City of Albuquerque

RE: CERTIFICATION FOR ALLIANCE ELECTRONICS
(M-21/D5C) RECEIVED JUNE 29, 1989

RE: DRAINAGE PLAN FOR ALLIANCE ELECTRONICS
(M-21/D5C) RECEIVED OCTOBER 25, 1988

RE: DRAINAGE PLAN FOR ALLIANCE ELECTRONICS
(M-21/D5C) RECEIVED SEPTEMBER 7, 1988

**SITE PLAN,**  
**INDEX TO SHEETS**  
 SHEET NO.  
**1**  
 JOB NO: 88-129 OF 6

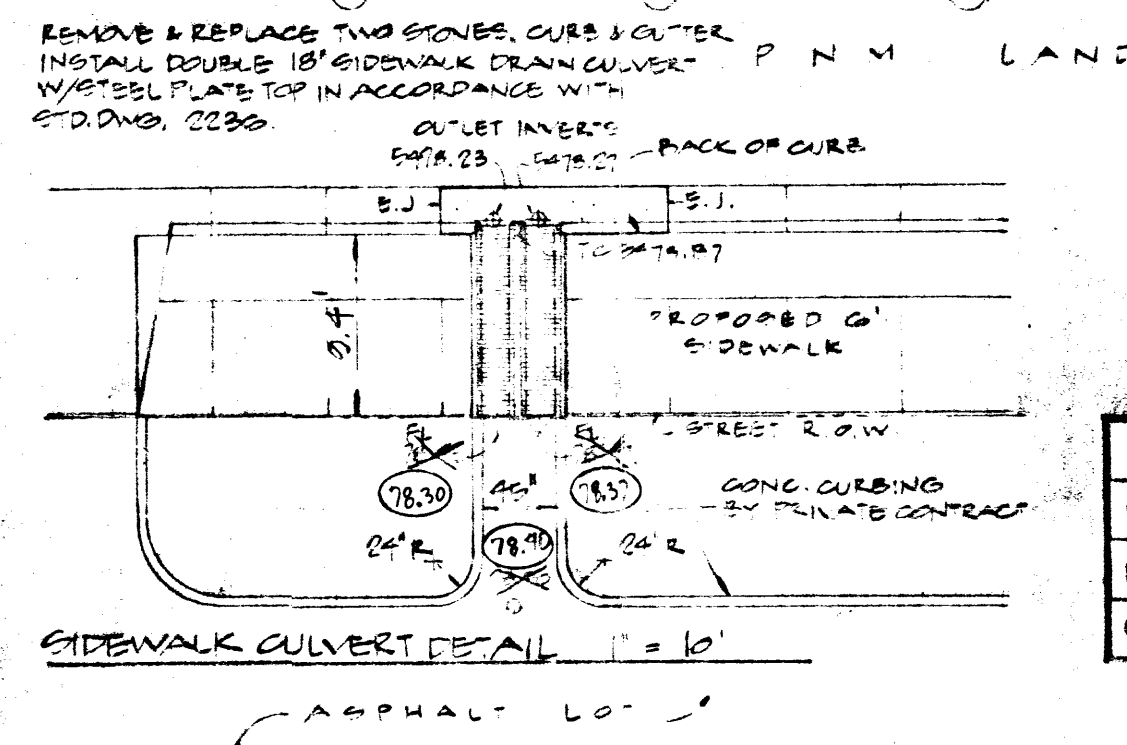
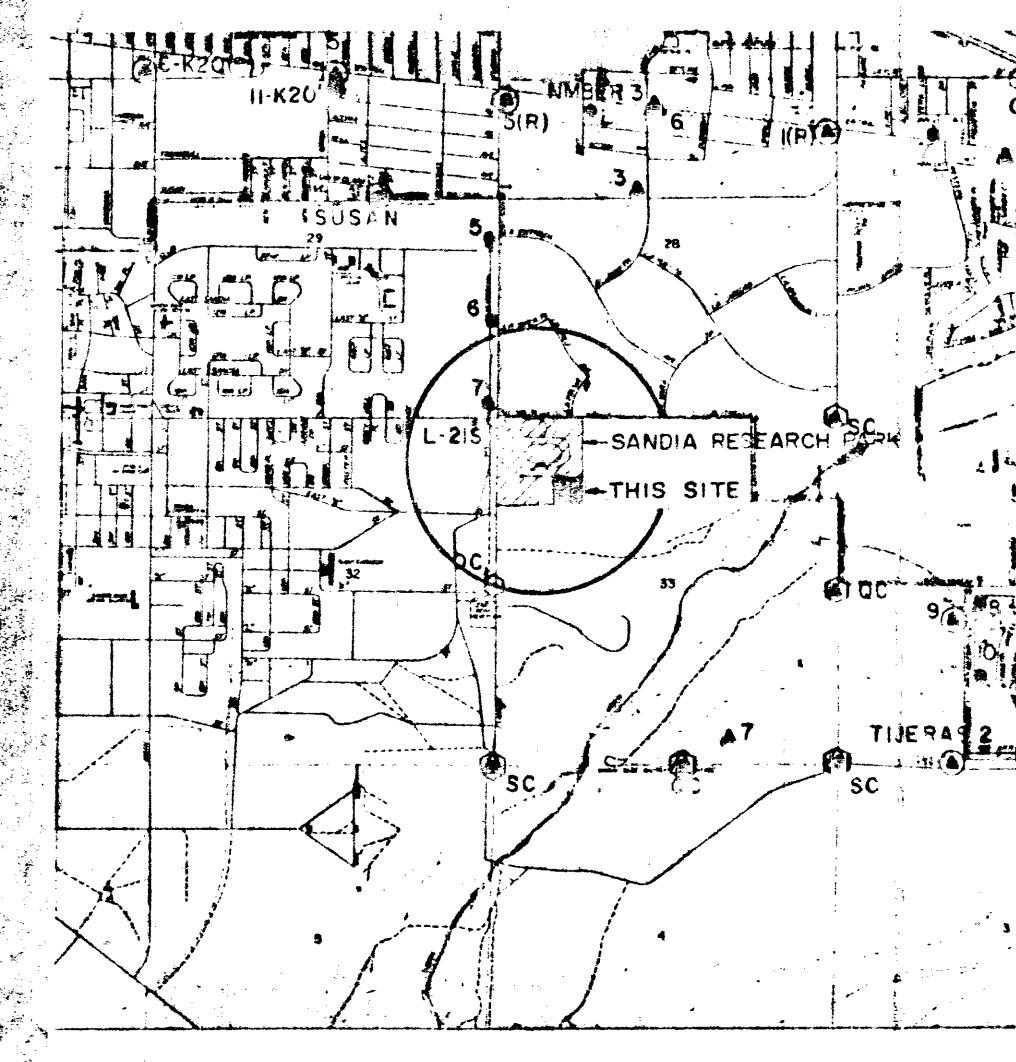
1. Please indicate the curb on the west property line.
2. Please show a legend for the drawing.
3. Please quantify the east offsite flows. How will the property be protected from these offsite flows.
4. The asphalt ponds will need detail asphalt construction work in order to attain the required volume. Due to this critical volume, we are requesting that the owner's engineer certify this project.

1. Contours supplied to us originally were not adjusted to MSLD and were not that accurate. The new plan reflects the actual lay of the site.
2. Turn-around details appear on sheet C-2 of 2.
3. Curb elevations at both ends of property and at drive cuts are all indicated.
4. Legend appears on new drawing.
5. Routing of offsite flows from the east into Research Avenue via graded swale have been interrupted by construction of turn-around. Our plan shows regrading of swale.
6. Pond spread and critical layout elevations within basin area have been indicated.
